# Submission on Bobs Farm Sand Mine Project SSD-6395 - Biodiversity

David C. Paull (MResSc)

29 January 2019

Figure 15-9 - Developed Conditions Drawdown Contours (m)

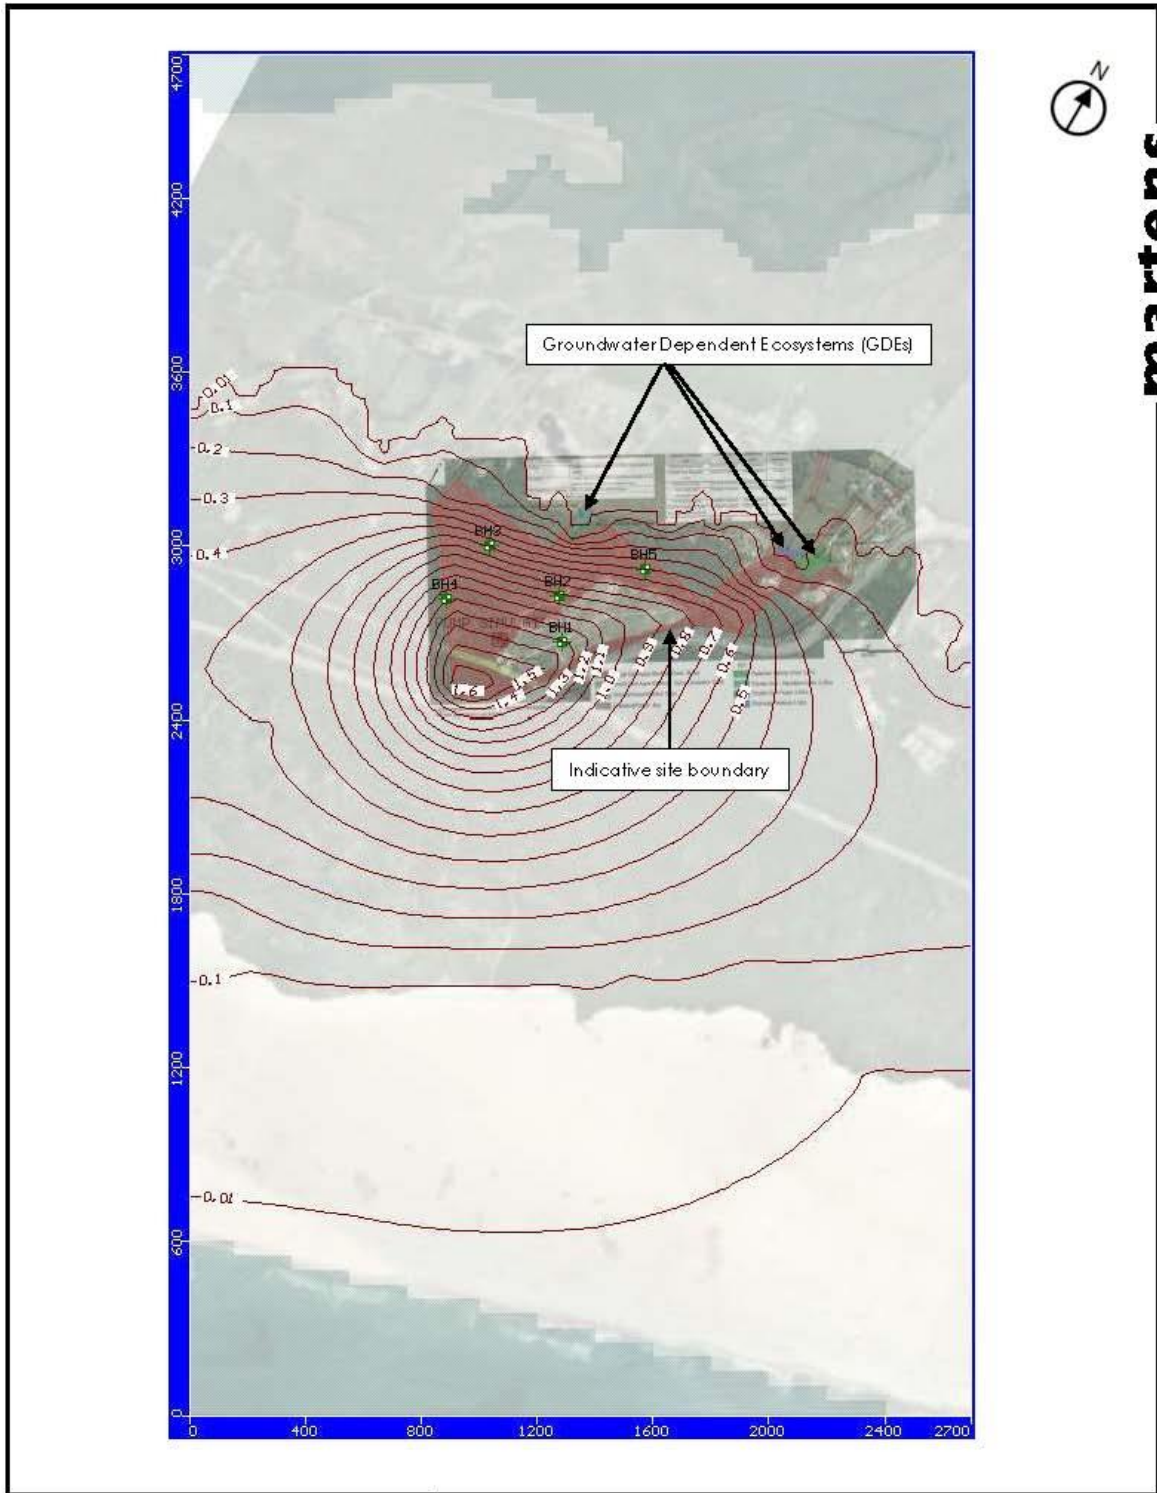
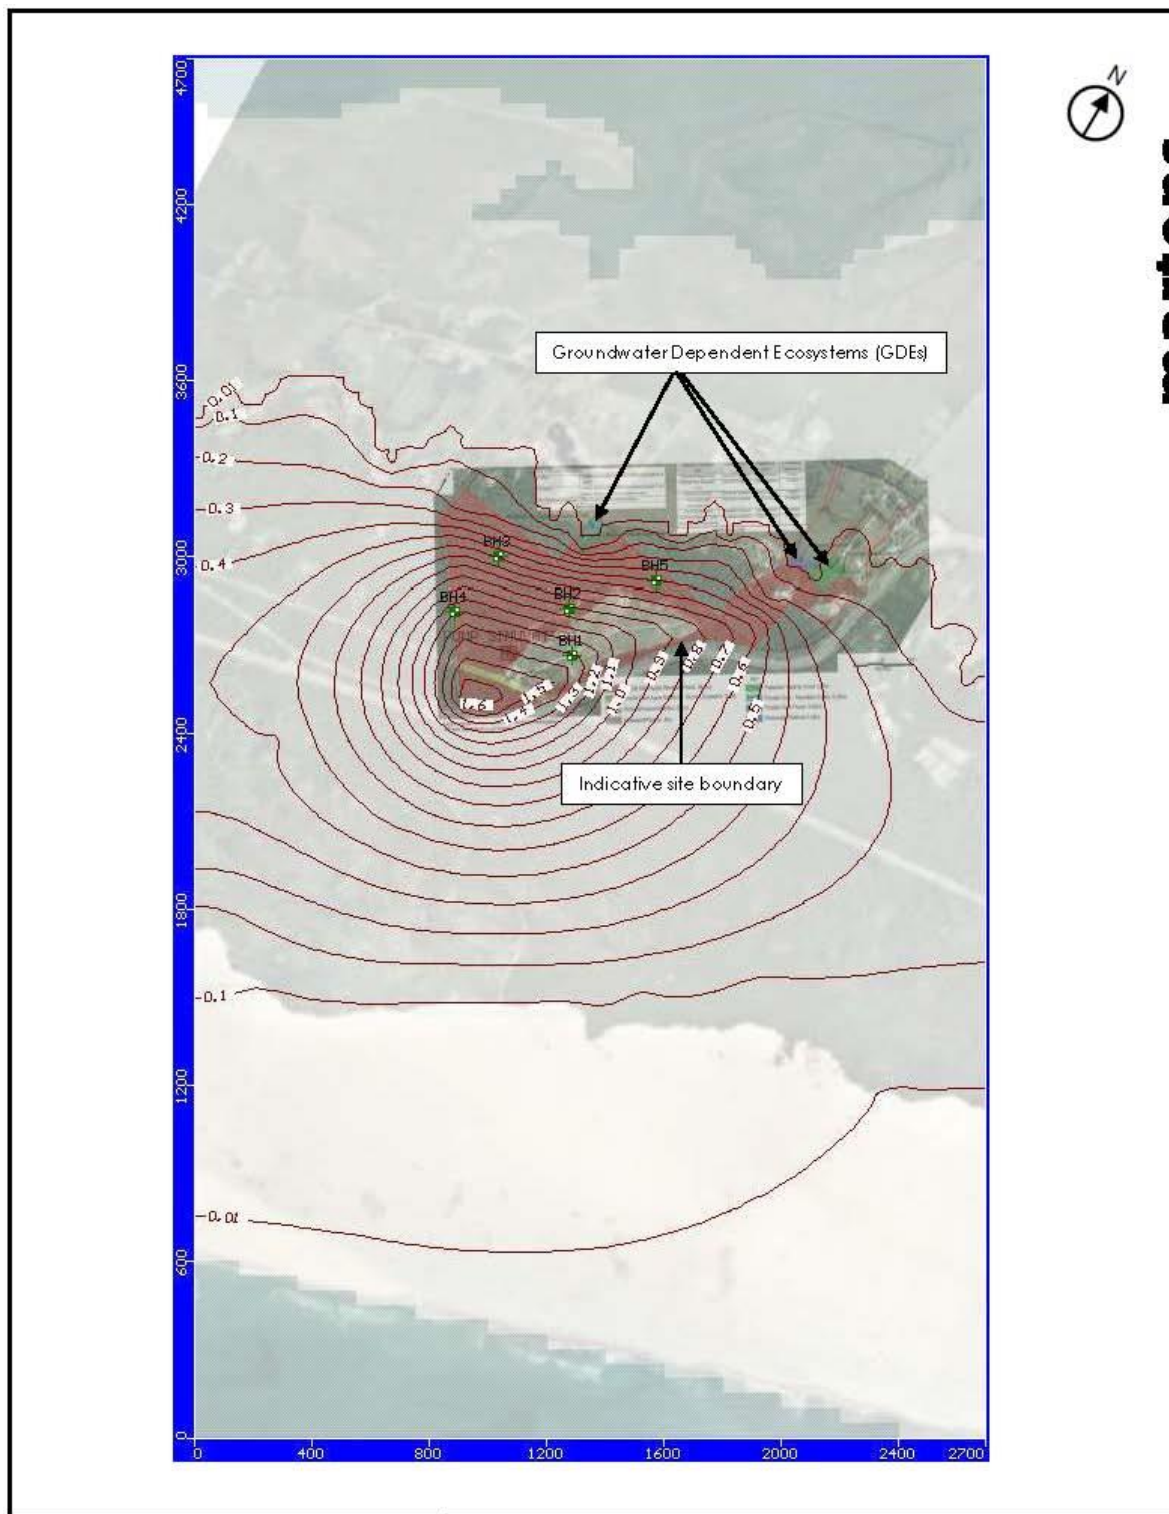
The proponent states that the proposed sand mine will require excavation below the groundwater level. They state that an assessment undertaken for the proponent (Martens 2015) found drawdown of the permanent groundwater system is modelled to be a maximum of approximately 0.07 m. They state that

*“based on the NSW Aquifer Interference Policy (Department of Primary Industries Office of Water, 2012) and the post Water Sharing Plan the local groundwater natural level range is of the order of 3 m (or more). The adopted permissible drawdown at a 40 m buffer from the GDEs is 0.30 m (i.e. 10% x 3.00). This drawdown threshold is met for vegetation communities exclusively reliant on groundwater. Consequently, based on modelling results, the proposed development does not exceed the drawdown impact criterion set out in the NSW Aquifer Interference Policy (NOW, 2012).”*

The ‘Risk Assessment Guidelines for Groundwater Dependent Ecosystems’ is the most appropriate methodology required to assess potential impacts on GDEs from mining activities and not the Aquifer Interference Policy which is assessment of risk to water-users. The proponent has failed to undertake a transparent assessment risk assessment to locally occurring GDEs that includes drawdown impacts but also any impact on the intensity and magnitude of horizontal flows. In this case the proponent has failed to meet the requirements as laid out in the SEARs.
